**EXTENSION TO PROPERTY @ 17 MUIR PLACE FORFAR**  
**FOR STEWART HAY**  
**REFERENCE 24/00010/FULL**

We refer to our planning application for the above site ....  
Further to receipt of your comments respond as follows.

PROPOSED PLAN @ 1:200 @ A3

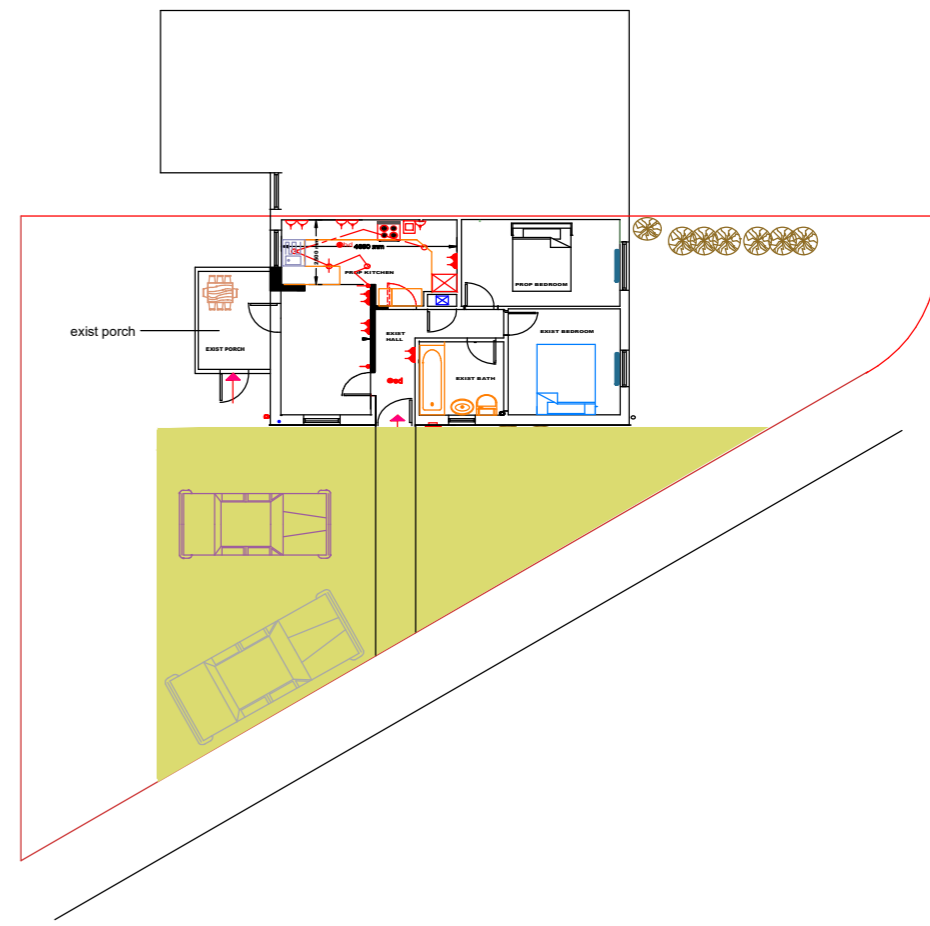
**Proposed floor plan**

1. neighbors nearest window shown
2. 45 degree lineage annotated however it should be noted that neighbor's extension breeches 45 degree lineage as indicated on site plan

**Existing floor plan**

- 1 labels correctly identified
